From: Nolan, Chris <Chris.Nolan@lancashire.gov.uk>
Sent: 28 September 2017 12:58
To: Robert Major; planning
Cc: LHS Customer Service
Subject: D3.2017.0695 - Lower Buck Inn, Twitter Lane, Waddington

Planning Application No: 3/2017/0695

Proposal: Change of use of existing single-storey detached store, and erection of additional single storey timber building to form two letting bedrooms for use in association with the Lower Buck Inn.

Location: Lower Buck Inn Twitter Lane Waddington BB7 3HU

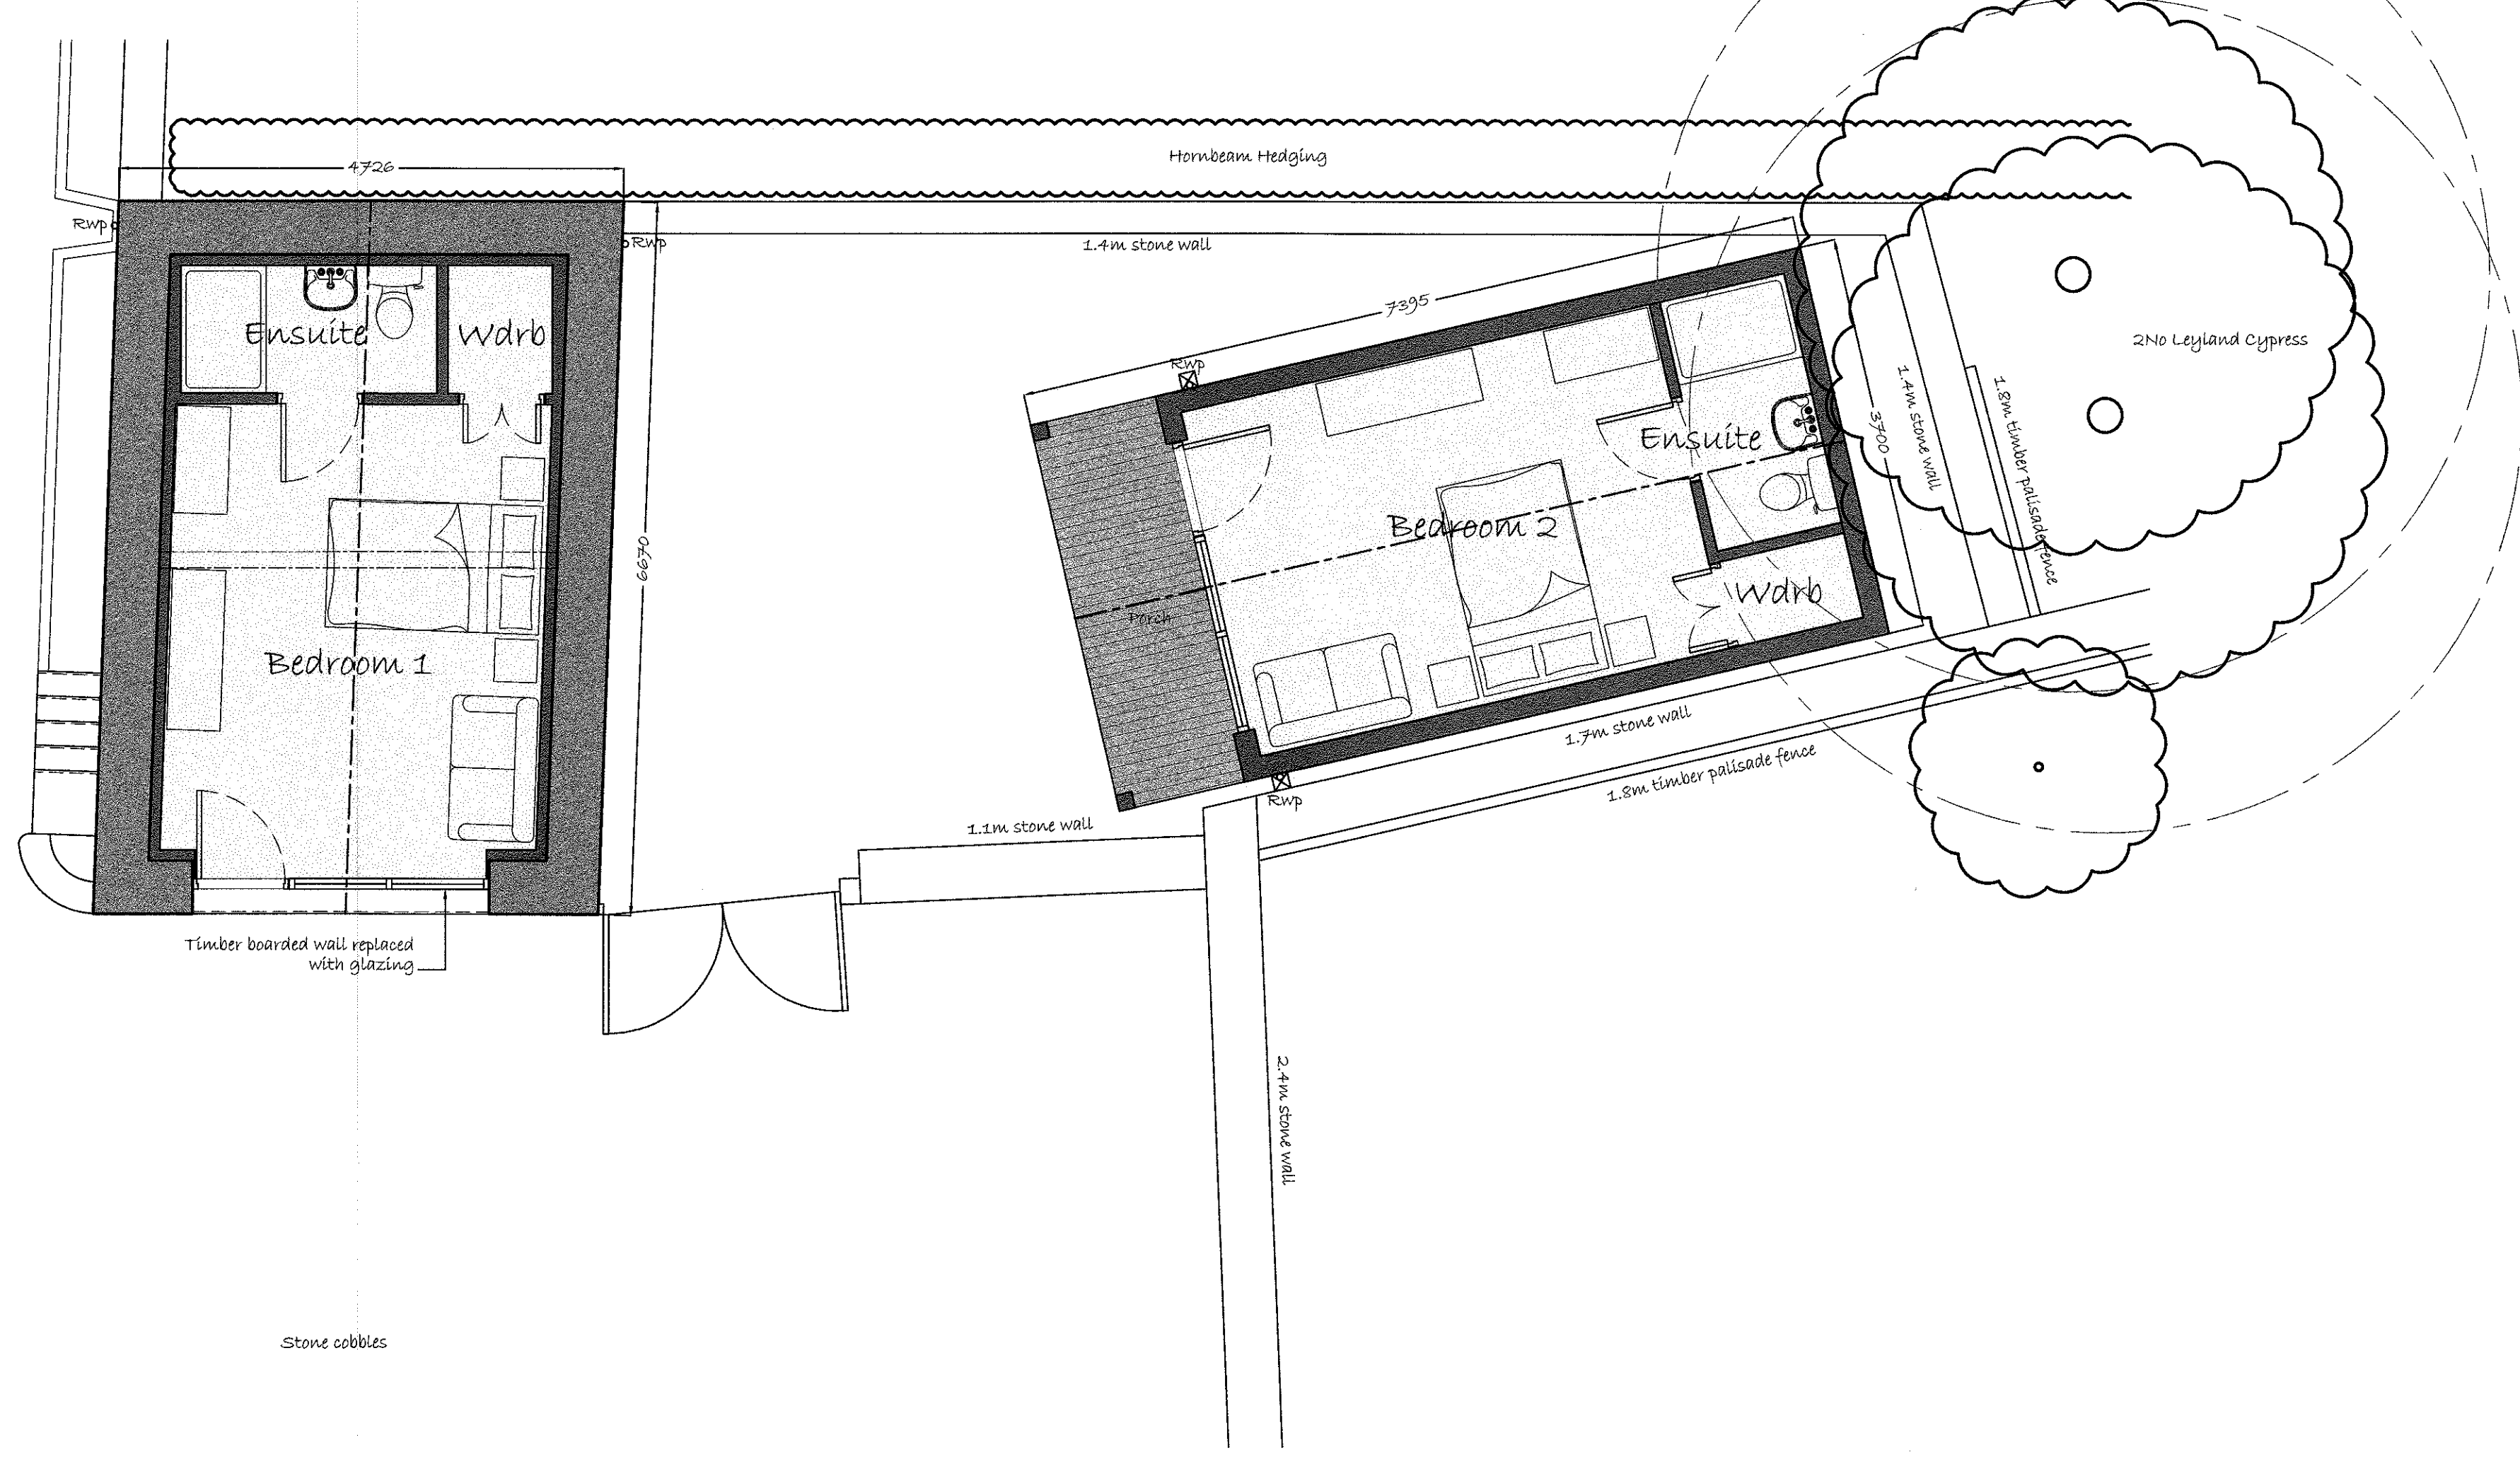
With regard to the above application. I have undertaken a site check this morning to look at overnight parking within the area and this has raised concerns with this application. Parking in Waddington can generally be described as difficult at any time but overnight this situation is exaggerated. This is true for Twitter Lane Close to the buck and confirmed by signs placed on the property indicating a drop off area and No Parking signs indicating access required at all times.

I feel that I would have to object to the application to build two new bedrooms to be let as accommodation attached to the public house unless the developer can prove that there is sufficient space available to park a vehicle per room. In addition to this I would be looking for details regarding the parking for the cottage let that is on the same site, the number of guest bedrooms there are within the public house and the parking facilities for the landlord. This information is required to ensure that the site, after this development is completed is assessed as a complete unit. I would like assurance that there is, within the curtilage of the property, sufficient space available to meet parking standards. I would be looking for parking spaces of 5.6m long by 2.4m wide for each necessary parking space. Preferably the details would be supplied on scaled plans of a minimum scale of 1:200.

If details can be provided to indicate that there is sufficient parking then I would look again at the application.
